212012 TAAF

CMRI Gene Technologies Building

STATE SIGNIFICANT DEVELOPMENT APPLICATION: SSD-45576956 RESPONSE TO SUBMISSIONS – TRAFFIC AND TRANSPORT

DRAWING NO.
DA_0101

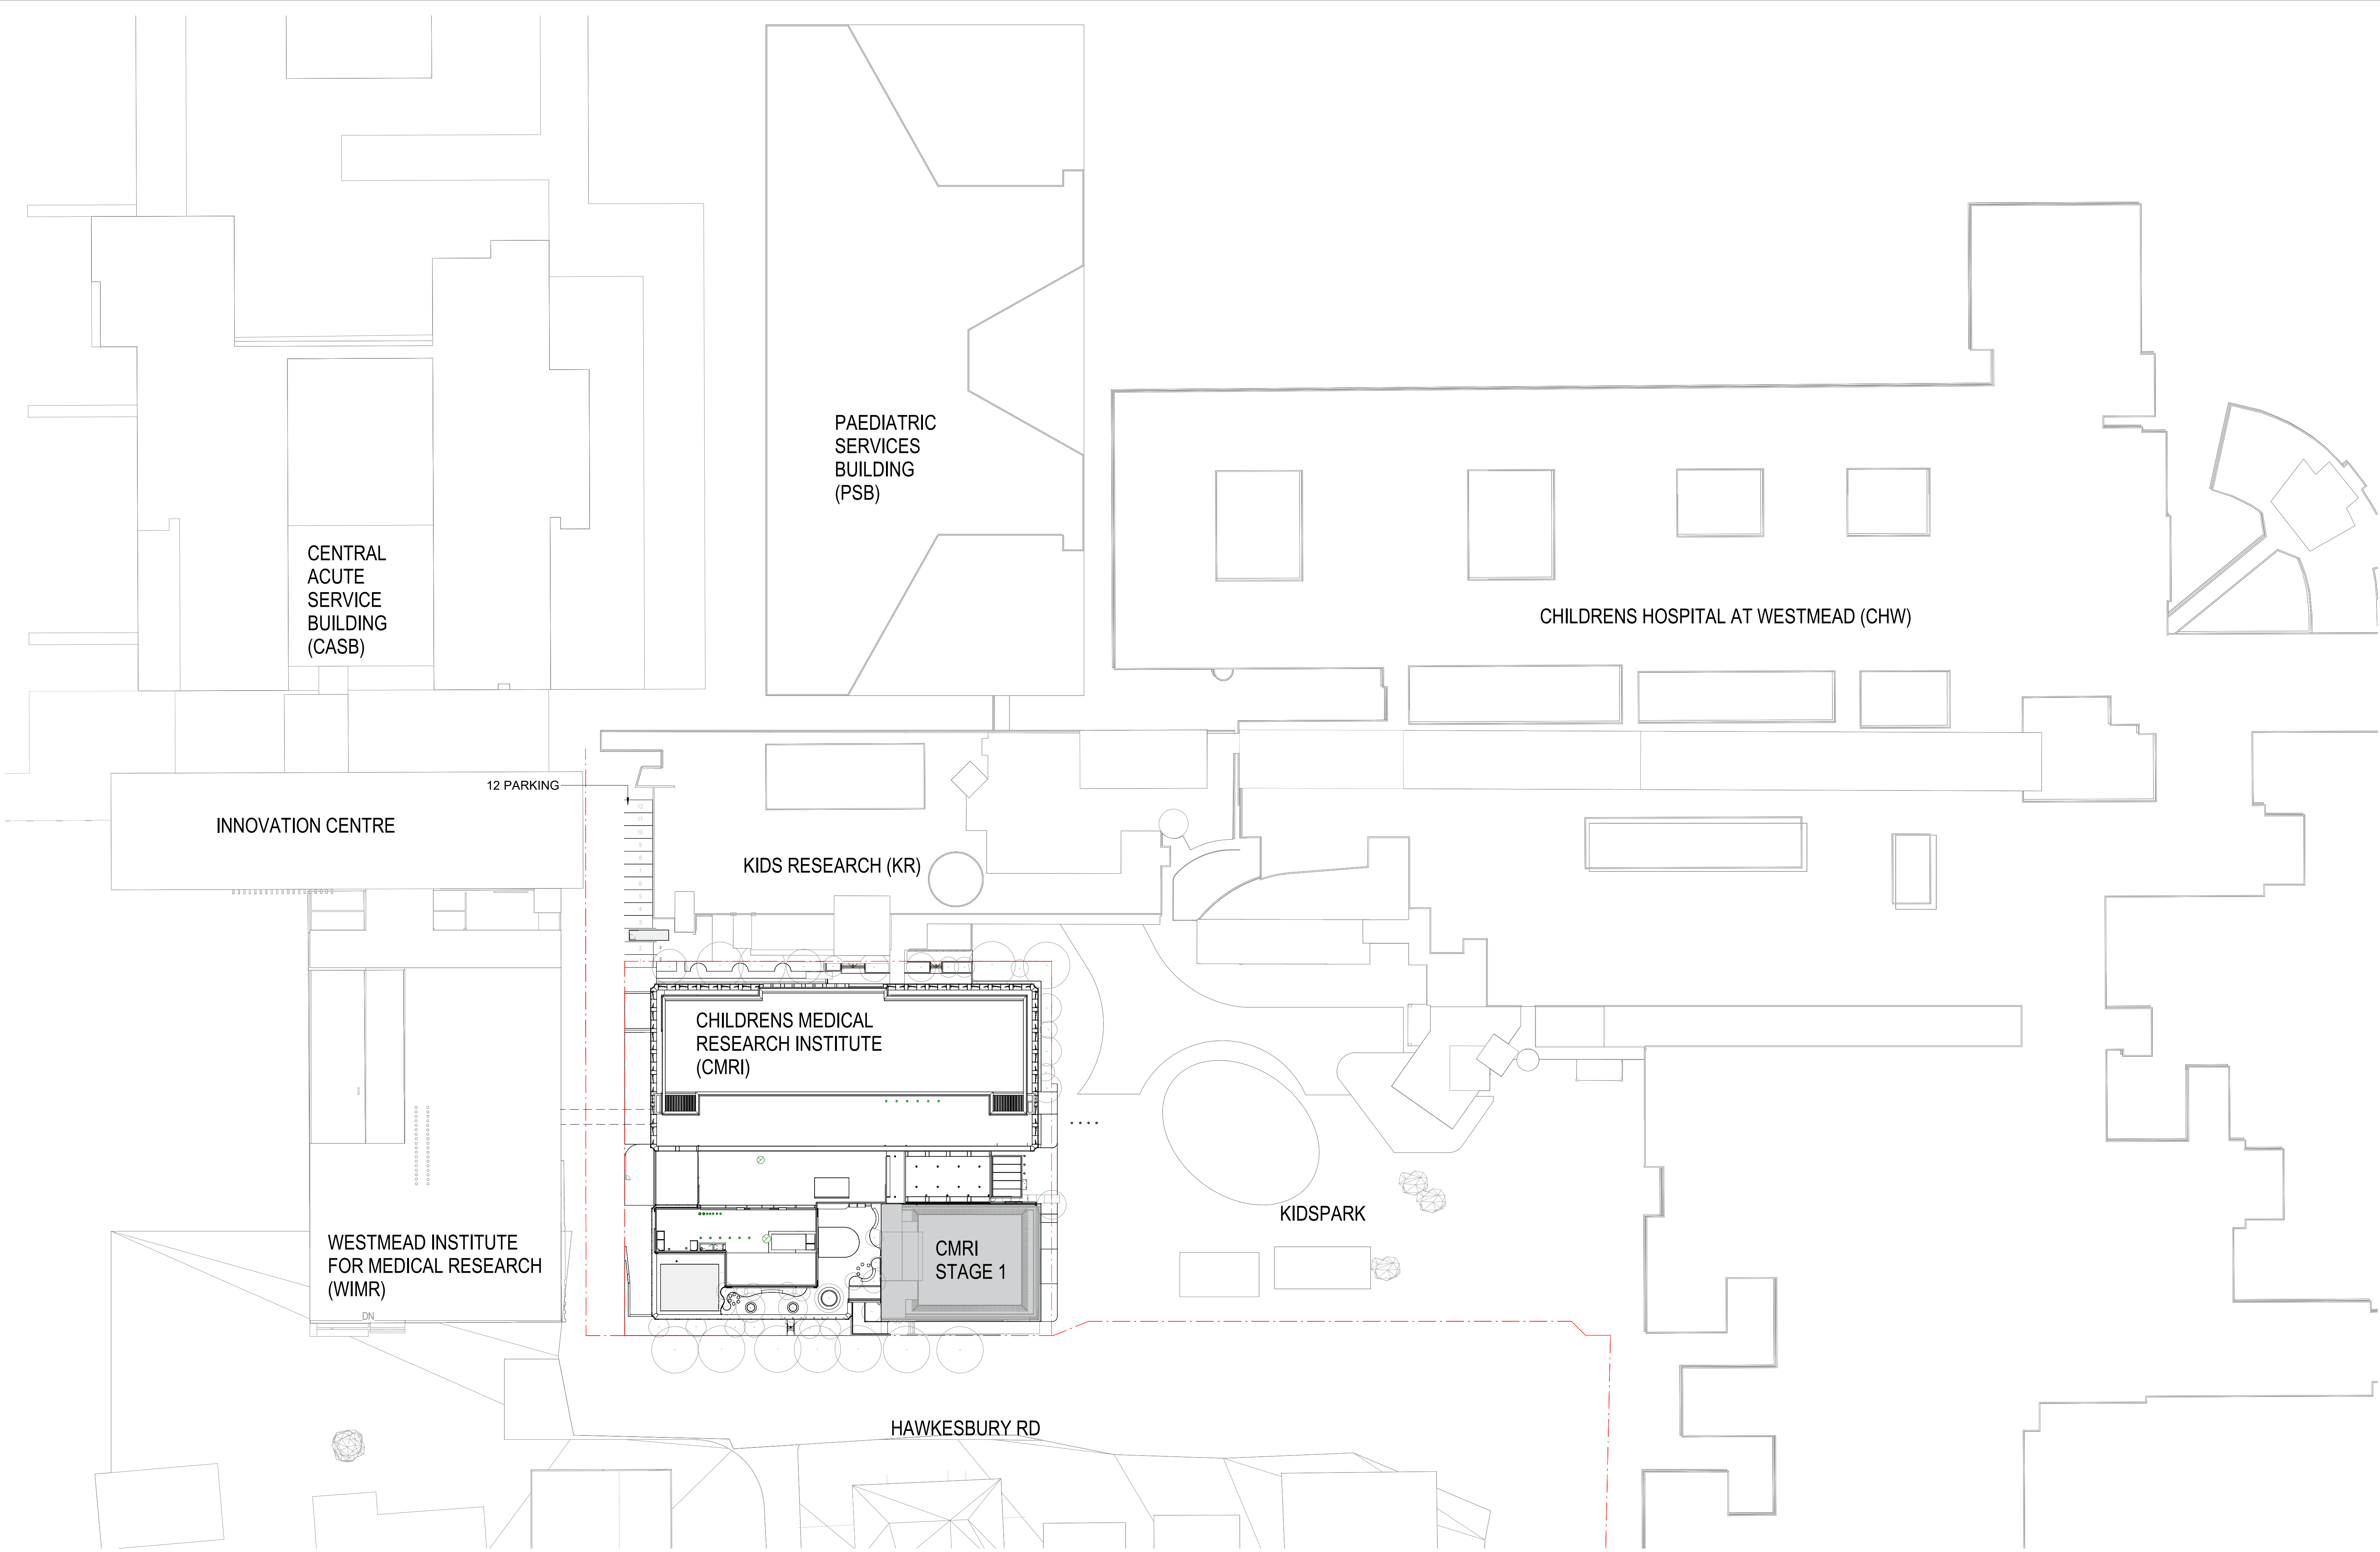
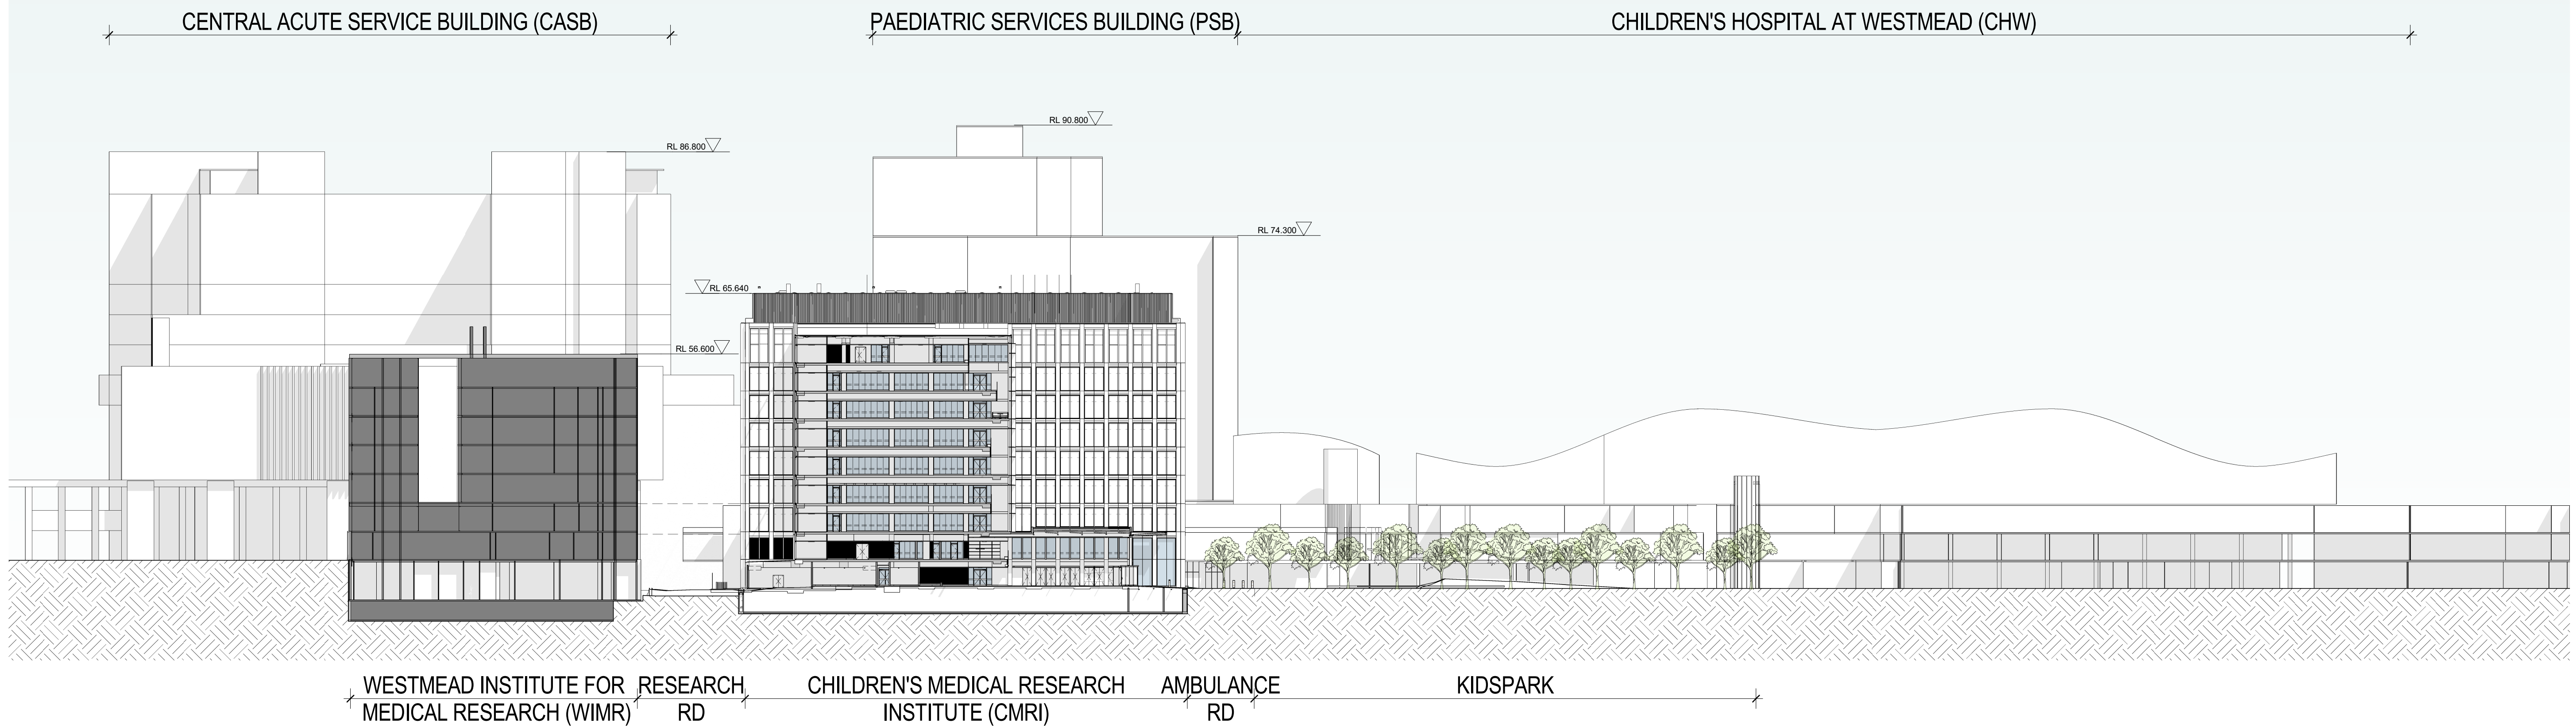
Comment: Part 6.6 of the EIS states that eight car parking spaces on the site are being removed and 12 offsite spaces will be reduced to 11. However, Part 3.5.2 of the Transport and Accessibility Impact Assessment states that 11 car parking spaces will be removed and nine car parking spaces will be retained upon completion. The Demolition – Phase B L2 Ground drawing seems to show removal of three car parking spaces in Research Lane. Please provide clarification.

Response: For clarity, the SSD works will result in a net reduction of 7 spaces along Research Lane. The latest design plans indicate that, out of the existing 19 parking spaces along Research Lane (previously 20 spaces prior to the water meter installation under a separate planning approval), a total of 12 spaces will be retained: 10 spaces adjacent to the Kid's Research building, and 2 spaces adjacent to the courtyard. The 7 angled spaces currently located beside the proposed CMRI development will be lost as a result of the future loading dock, which is proposed at such location.

Refer to the latest demolition plan prepared by Hassell (drawing no. DA_0101 [rev. D], dated 14 August 2025) which illustrates the latest carparking availability along Research Lane upon completion of construction (see Figure 1).
